Re: Proposed Plans for Garcia Mobile Home Park

Re: Garcia Mobile Home Park Drainage Report

Re: Garcia Mobile Home Park (Z-78-31)

GARCIA MOBILE
HOME PARK
DRAINAGE REPORT

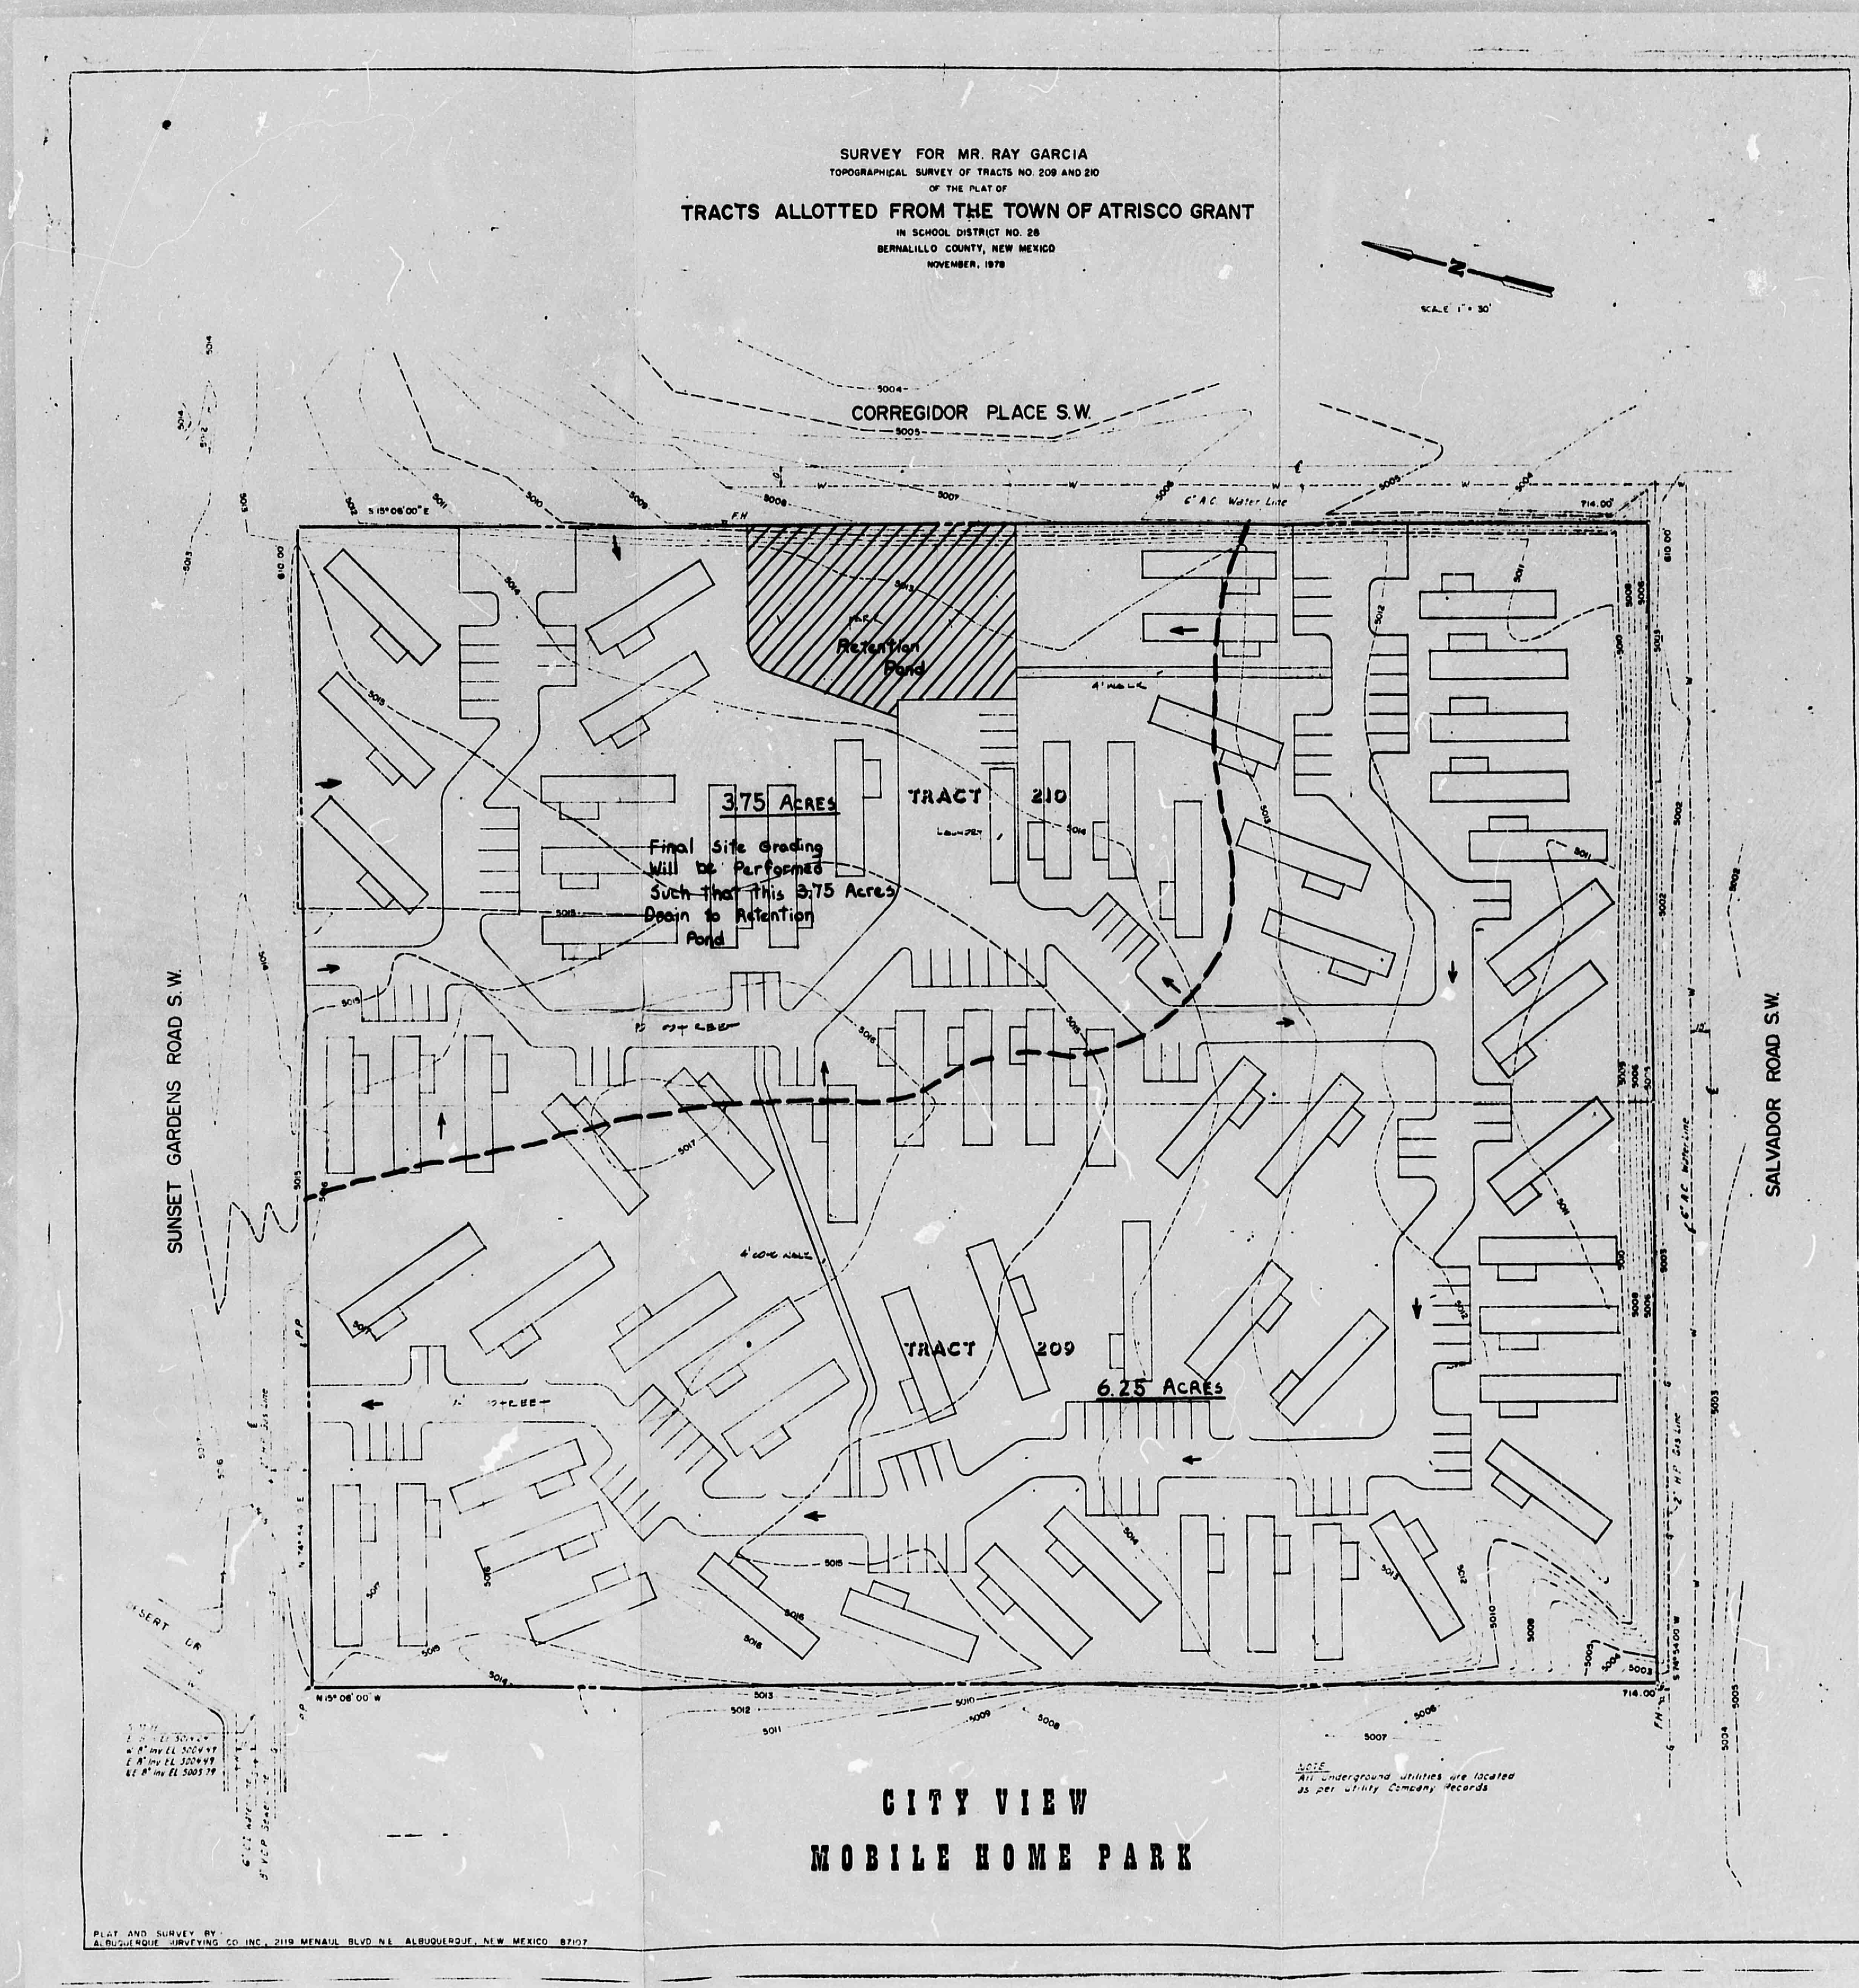
1. The proposed "internal" drainage plans and ponding concepts discussed at the meeting are satisfactory.
2. Required retaining walls are acceptable as long as footing remains within property boundary. Concrete slope paving is also acceptable as a means of slope stabilization. Areas of slope paving may be allowed to drain away from the site where this type of construction is employed.
3. If a privacy fence is built at ground level within "park" it shall be constructed in accordance with the zoning requirements.
